Planning Application Ref: AW/195/19/TC

Location: 12 Kingsway, Aldwick, PO21 4DQ

Description of works: Prune 1no. cedar tree by 1.5 - 2m on west aspect within the Craigweil House, Aldwick conservation area

T1 Cedar (cedrus libani)

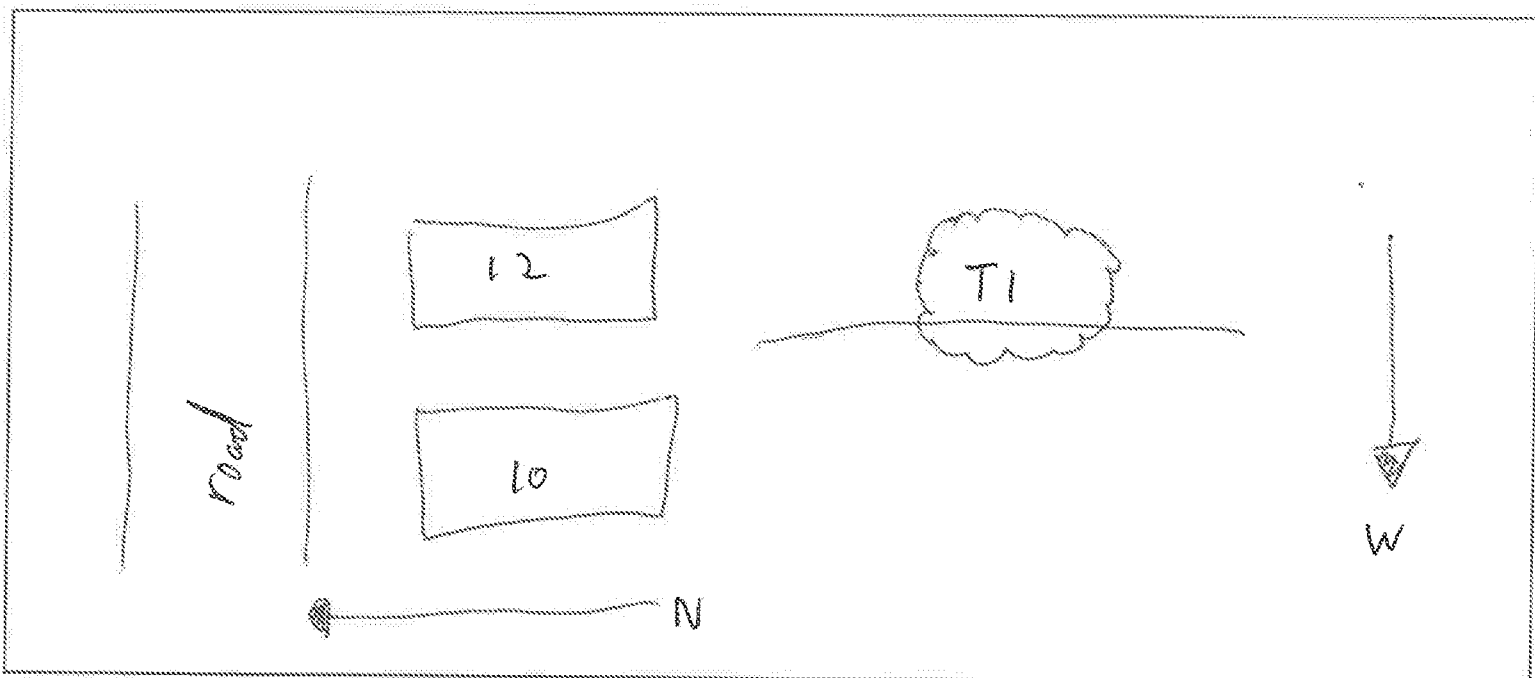
- The applicant is seeking to reduce the lateral spread of the tree on one aspect by approximately a third.
- The vast majority of needle-bearing branches are found on the crown periphery, a typical characteristic of this tree type. As such, the reduction of individual limbs and branches should only ever be slight, if undertaken at all. Cedar trees are not considered to be tolerant of hard pruning.

- This tree requires careful management that respects its age and vulnerability to environmental changes and disease progression. There is no obvious justification for the work on arboricultural grounds.
- I believe that the work proposed will irrevocably spoil the crown profile to the extent its landscape value and visual amenity will be permanently diminished. Furthermore, I expect the work would have a harmful effect on its ongoing health and vitality, at a time when it appears to be under physiological stress.

- I recommend **REFUSAL** for this application and that we make an Order to preserve this tree in the landscape and better control its future management.
- The appropriate TEMPO form and GIS plan to assist you in making the Order can be found at this location: [N:_EveryoneFolders\Mark Warwick\Aldwick.Kingsway.12](N:_EveryoneFolders\Mark Warwick\Aldwick.Kingsway.12)
